Inspector's Report ABP-309387-21

Question	Whether or not replacement of a wastewater treatment plan is or not development or is or is not exempted development.
Location	Potter's Point, Brittas Bay, Co. Wicklow.
Declaration	
Planning Authority	Wicklow County Council
Planning Authority Reg. Ref.	EX80/2020
Applicant for Declaration	Potters Point Ltd
Planning Authority Decision	Is not exempted development
Referral	
Referred by	Potters Point Ltd
Owner/ Occupier	Potters Point Ltd
Observer(s)	None
Date of Site Inspection	13/4/2021
Inspector	Suzanne Kehely

Scales: 1:250 @ A1 / 1:500 @ A3
Drawing No: 20104-JBB-XX-XX-Z-1201
Rev: P01

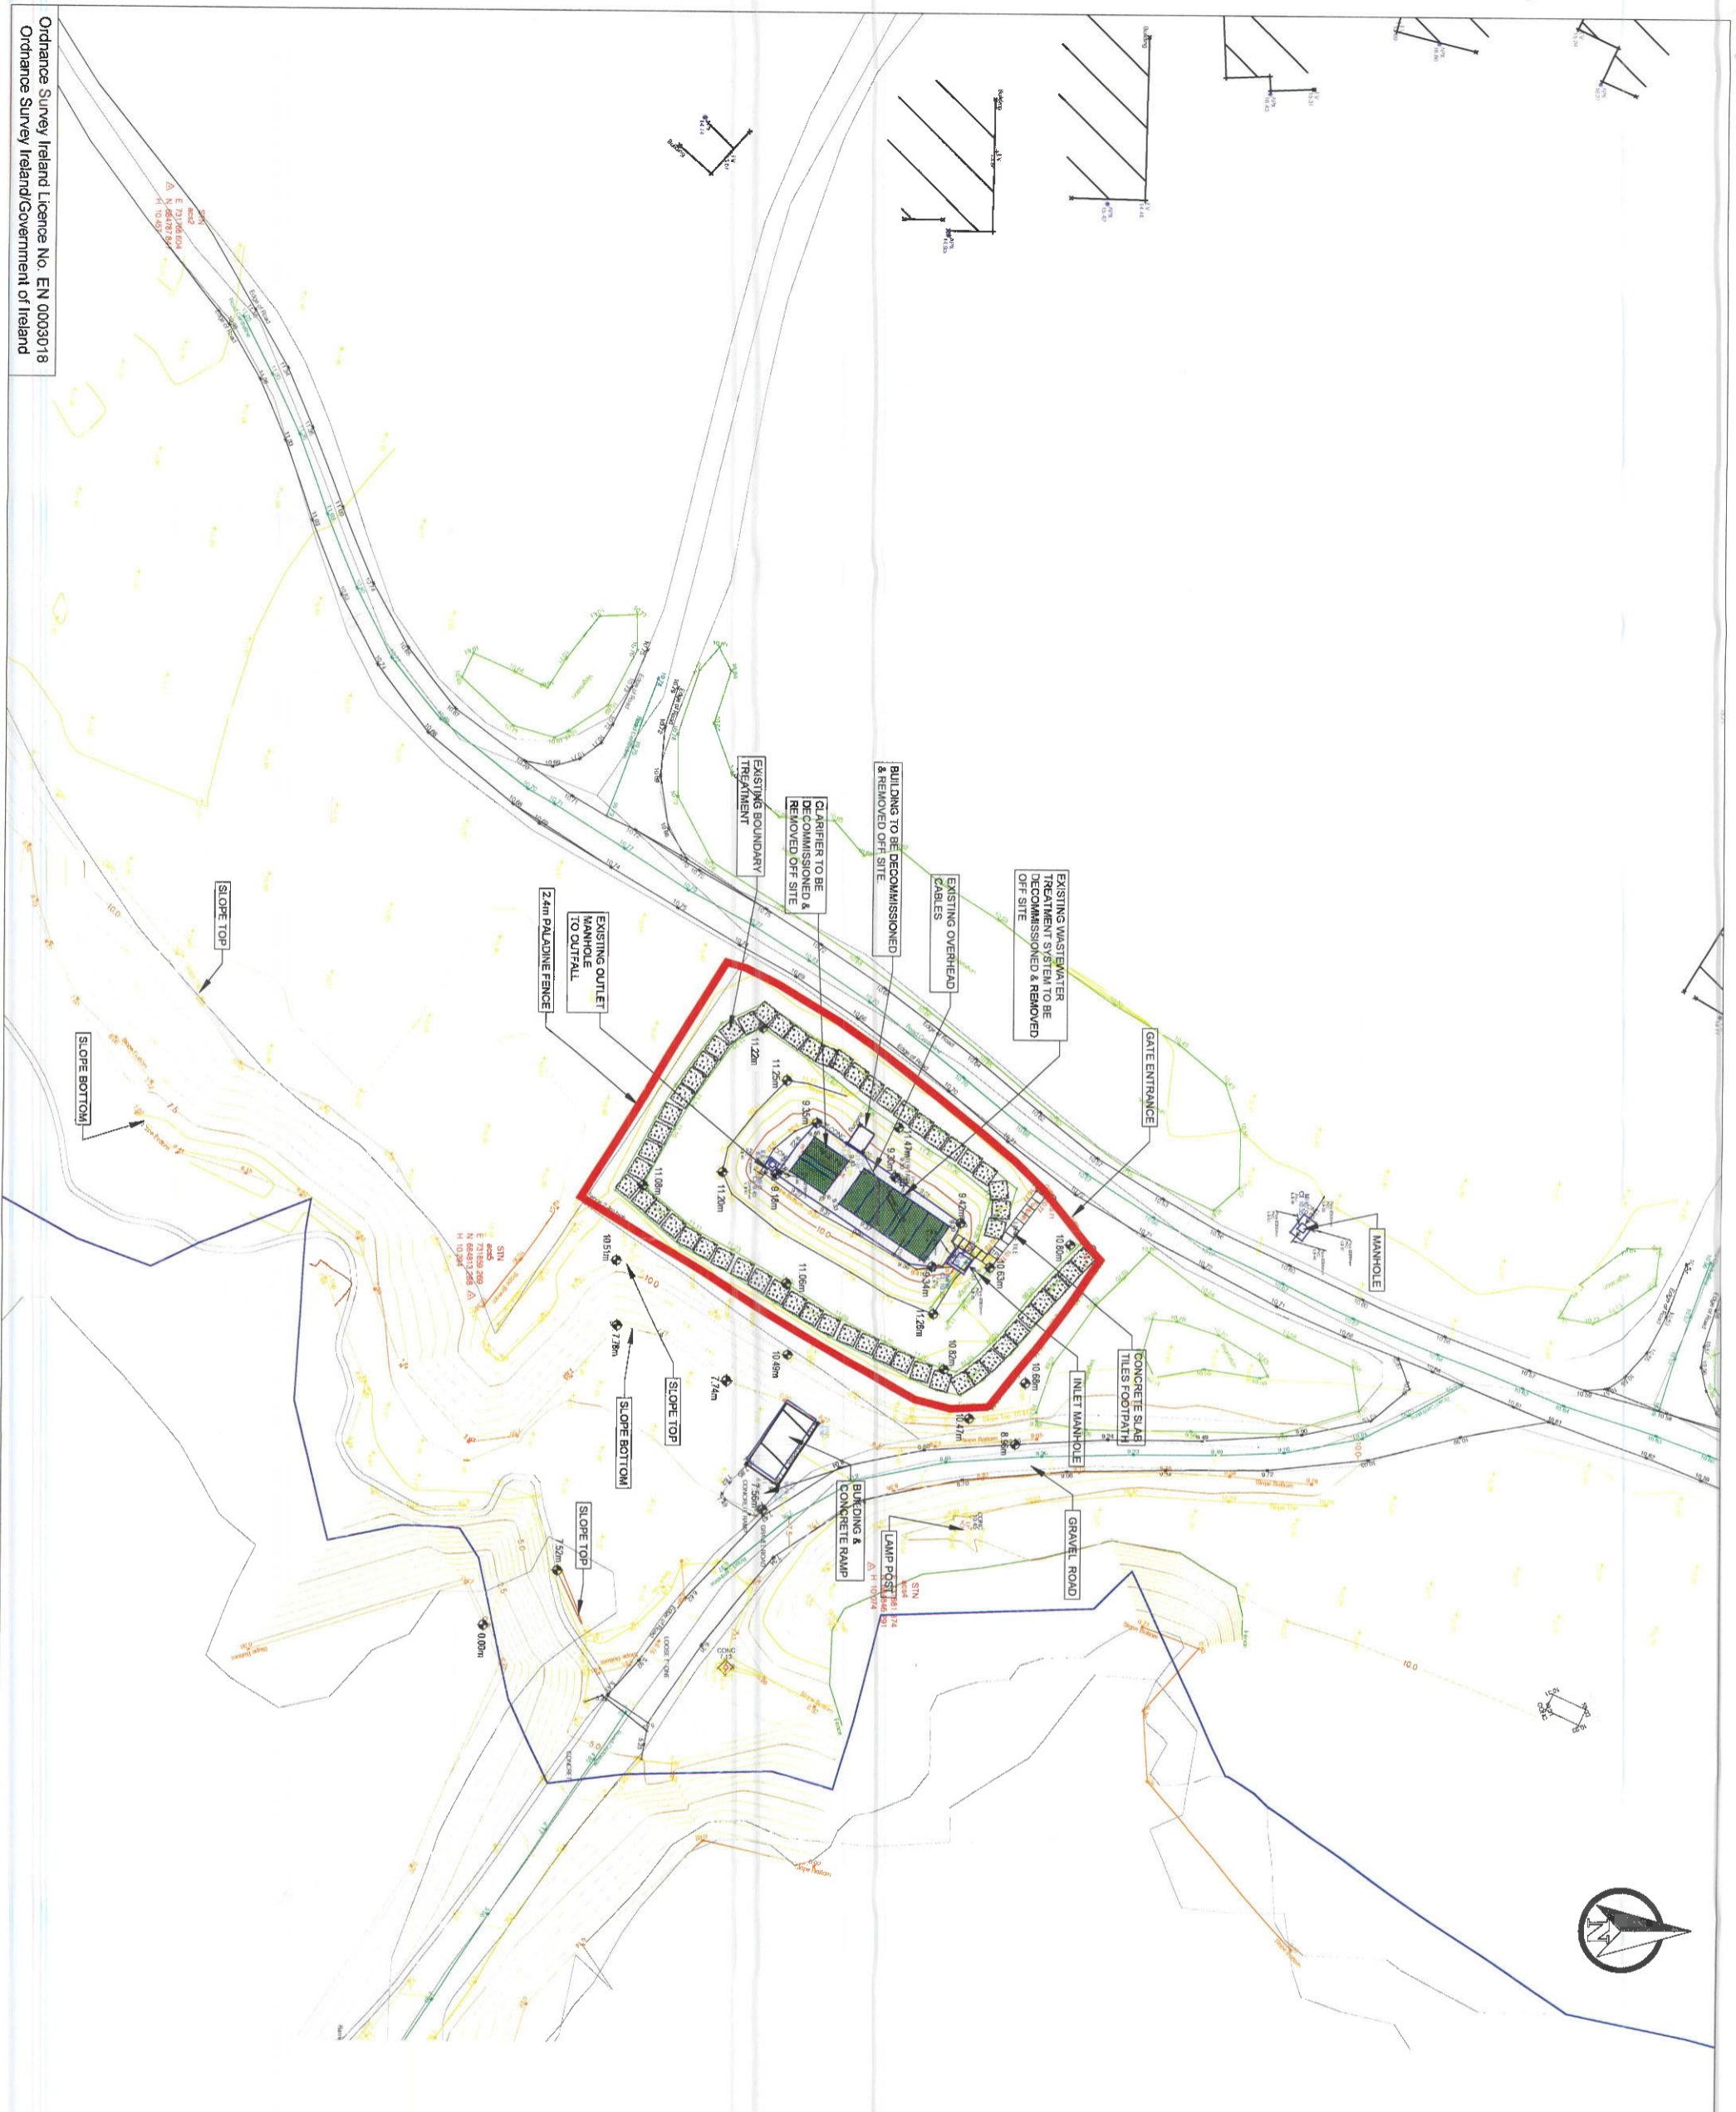
- 9.5.7. The submitted plans show a detailed layout of the treatment plant but do not show any outfall point although it is required to be at least 30m beyond the shore line. It is likely to be down gradient to the sea at a point north of the coastline of the SAC. However in the absence of such details of flow and discharge, a pathway or lack of cannot be determined.
